CROSSROADS MIXED USE FILING NO. 2

CONSTRUCTION PLANS

TITLE SHEET

STREET IMPROVEMENT PLANS

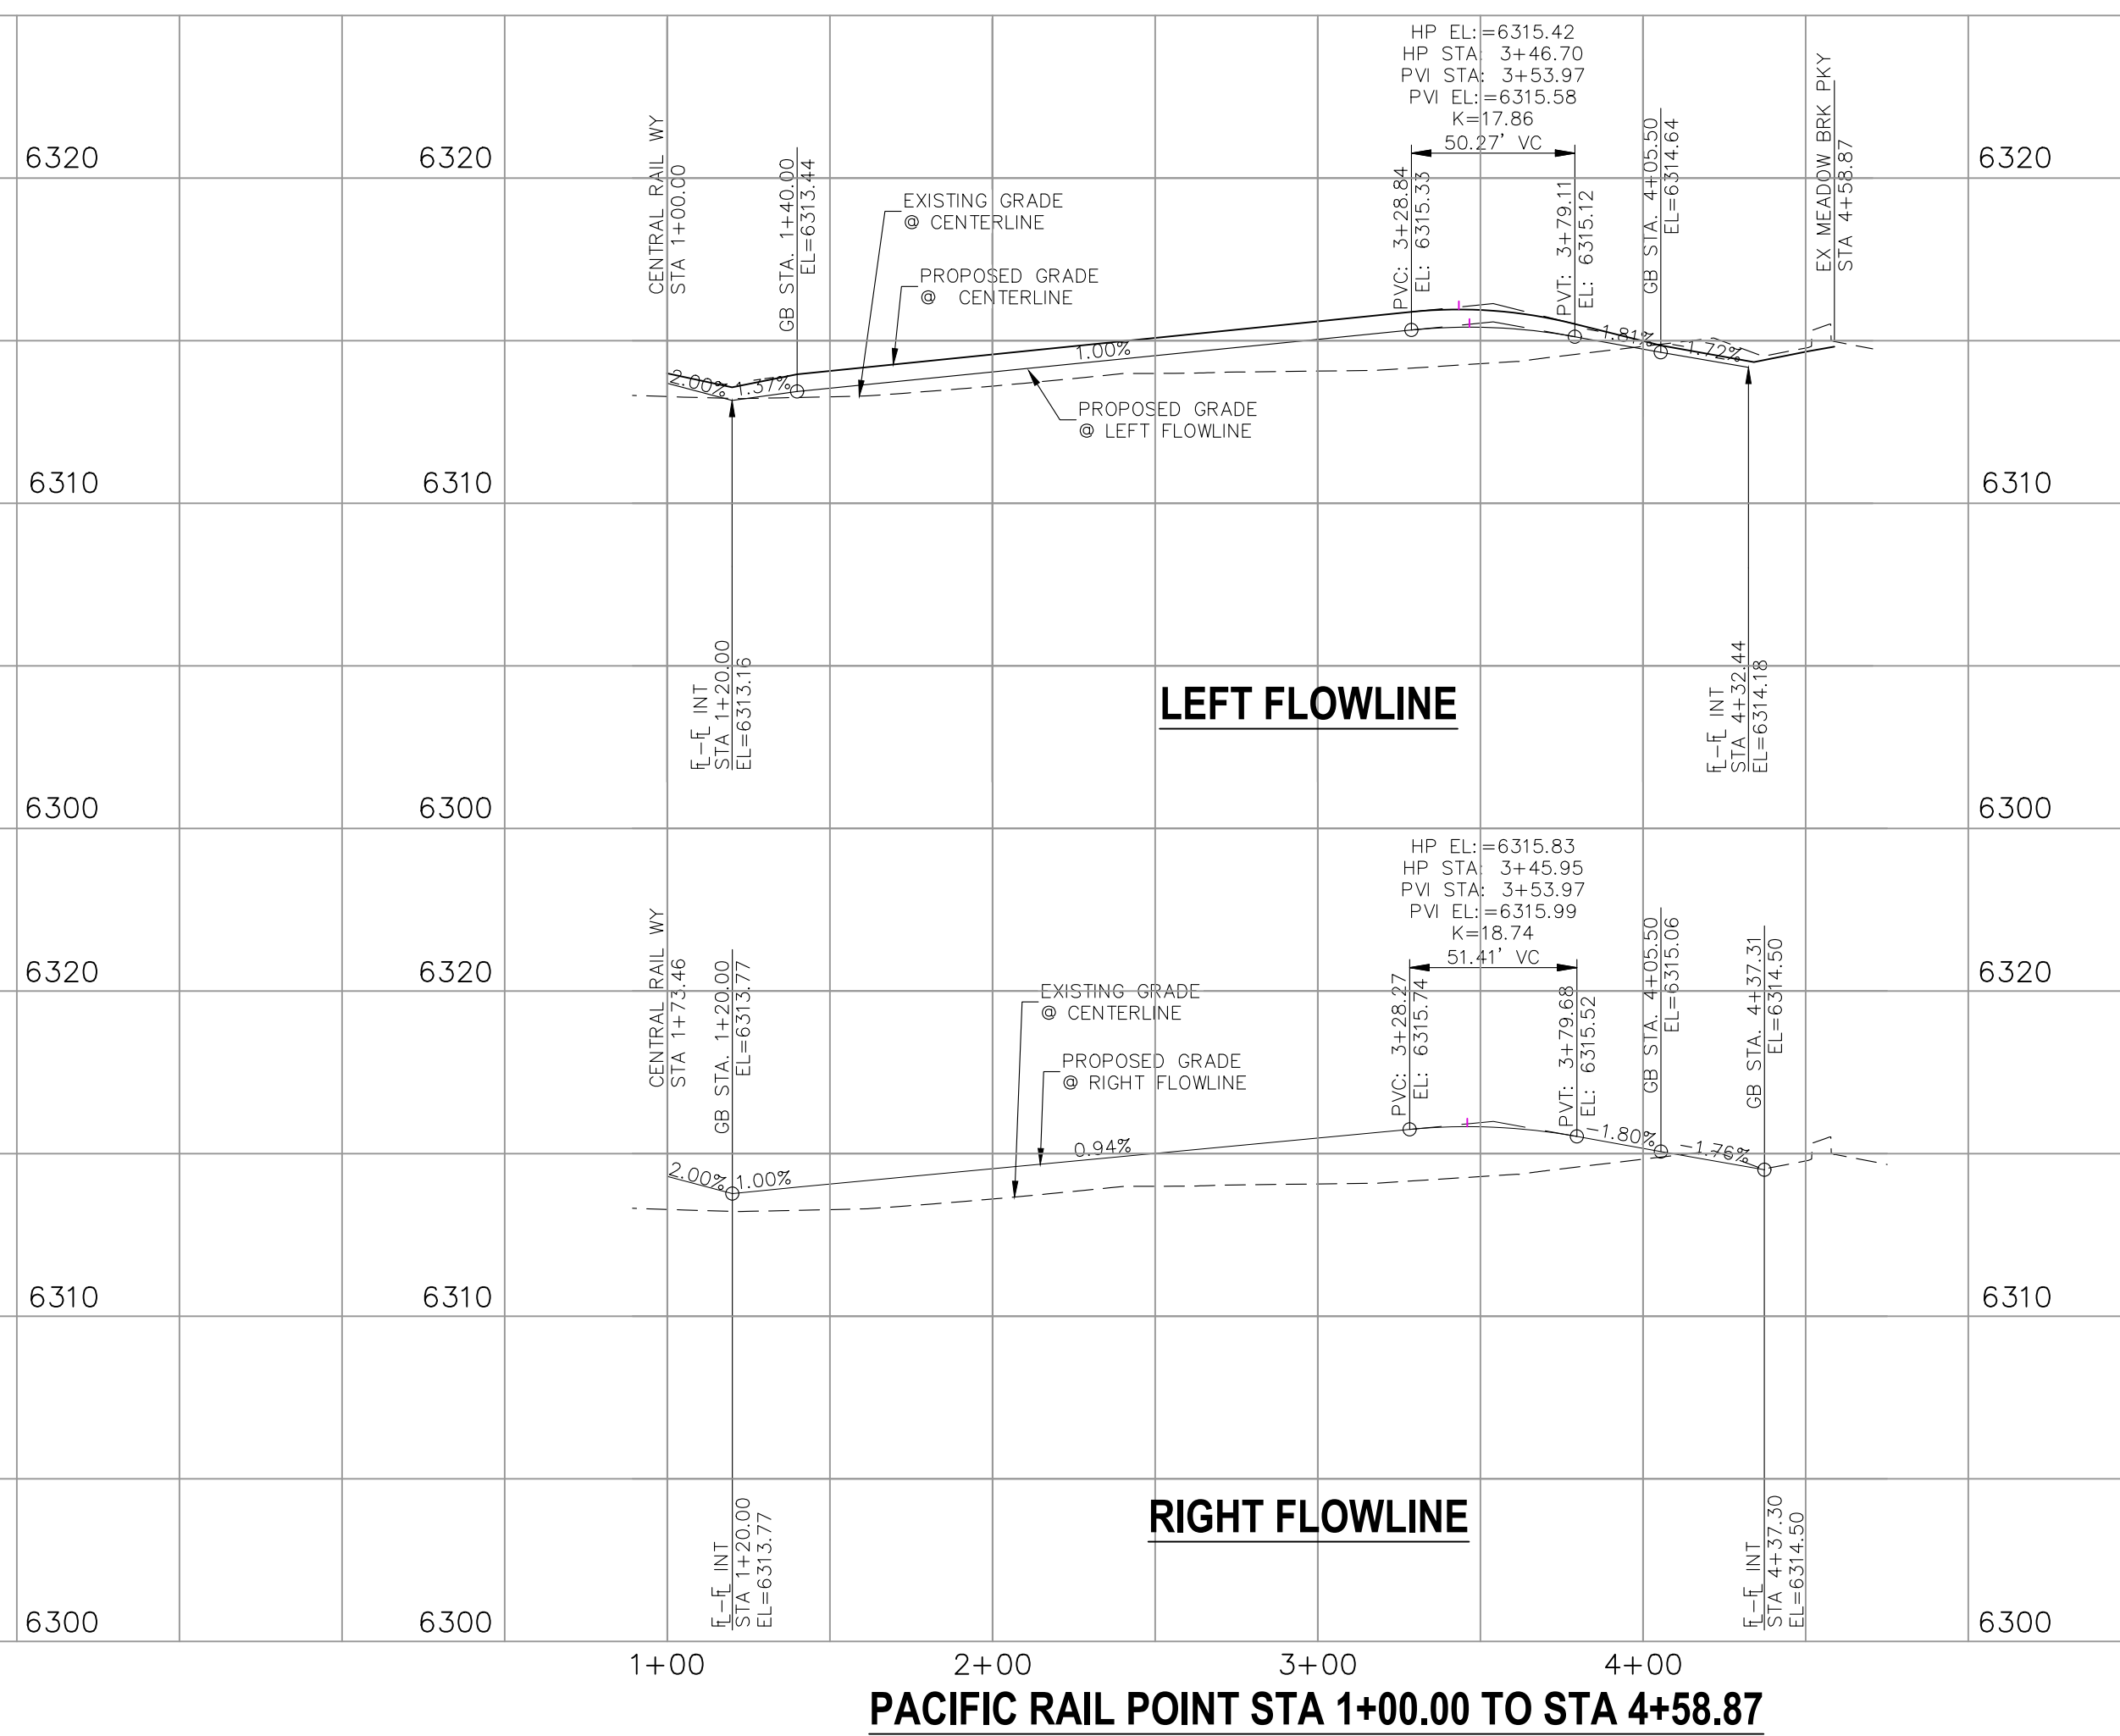
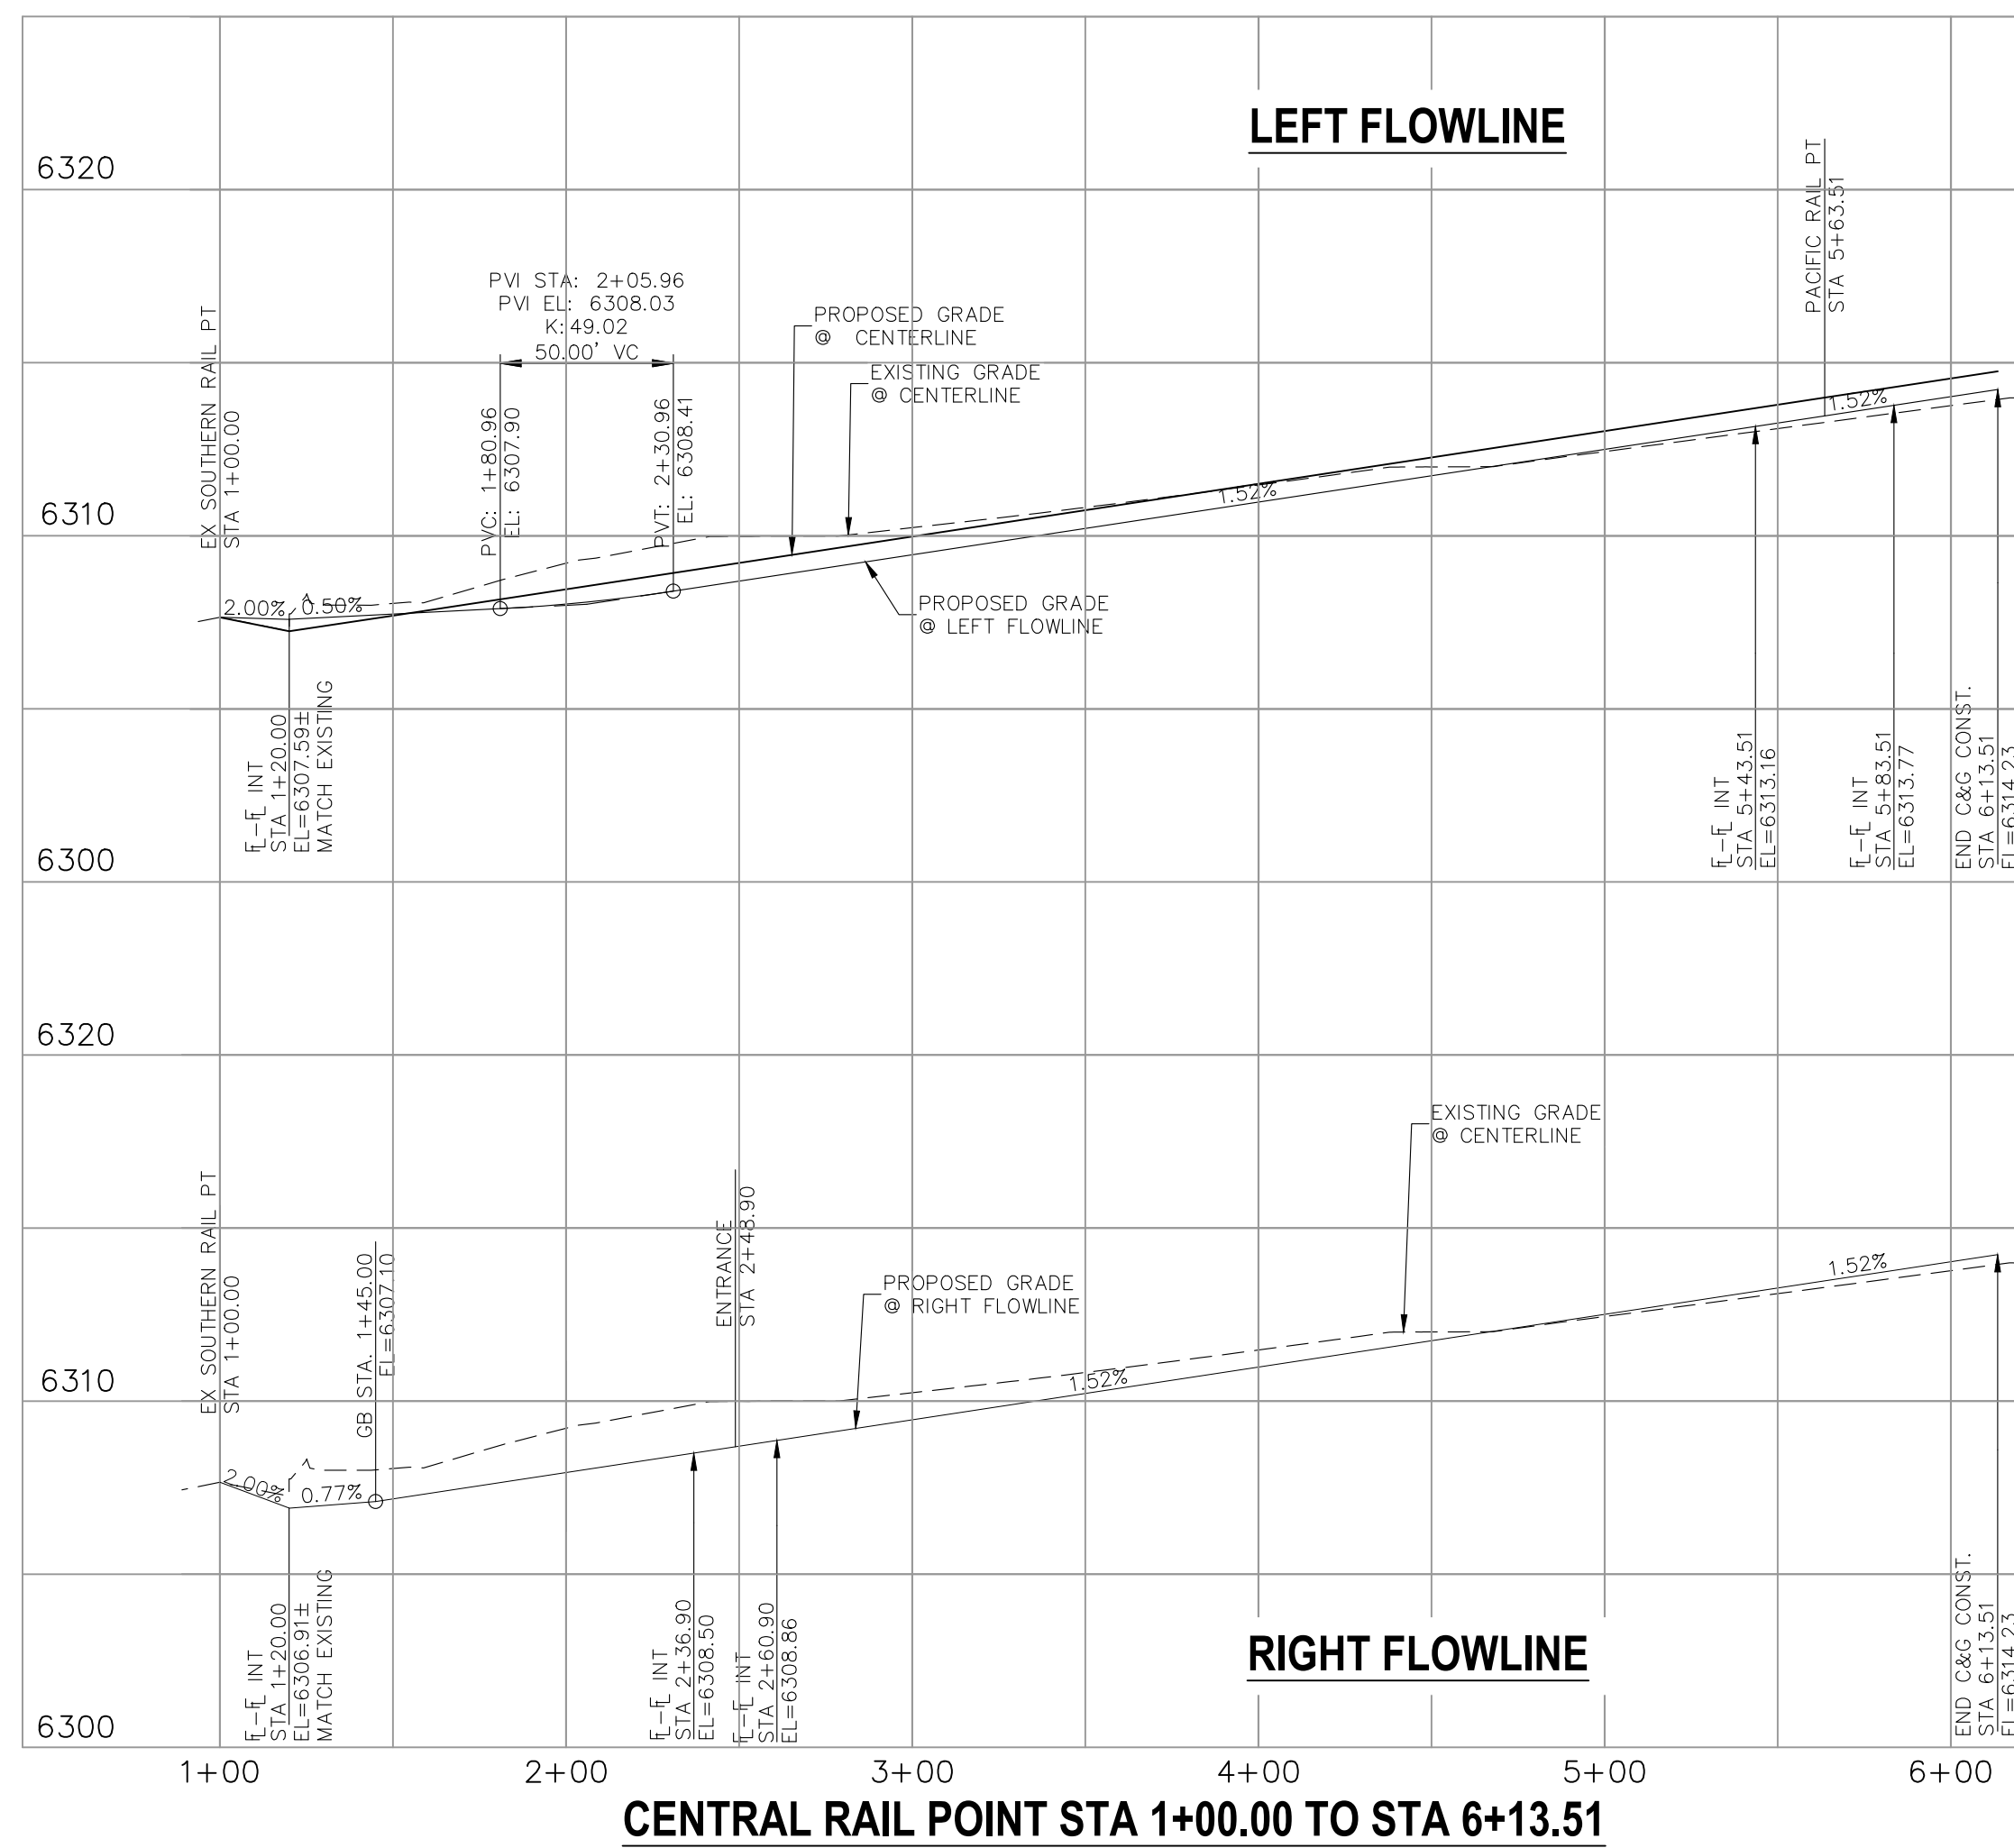
This is shown as private on drainage report. Revise to label all storm as private.

Revise to provide a sidewalk/crosswalk across proposed curb ramp per ECM 2.5.2.C.3 and 2.5.2.C.4.

There are several inconsistencies between these drawings and the drainage map proposed conditions. These include: labeling of private and public storm sewer, mismatched pipe sizes, and missing proposed swales. Coordinate with drainage engineer to remove inconsistencies between the two documents.

Provide centerline line bearing and distance and curve data.

Add property lines to the legend and show on plans.

The inconsistencies of private versus public storm sewer and pipe sizes have been addressed.

A sidewalk/crosswalk has been added across the proposed curb ramp.

The inconsistencies of private versus public storm sewer, pipe size, and missing proposed swales have been addressed.

All line and curve data has been added for the centerline and the PCRs.

The property lines have been added to the legend and plan view.
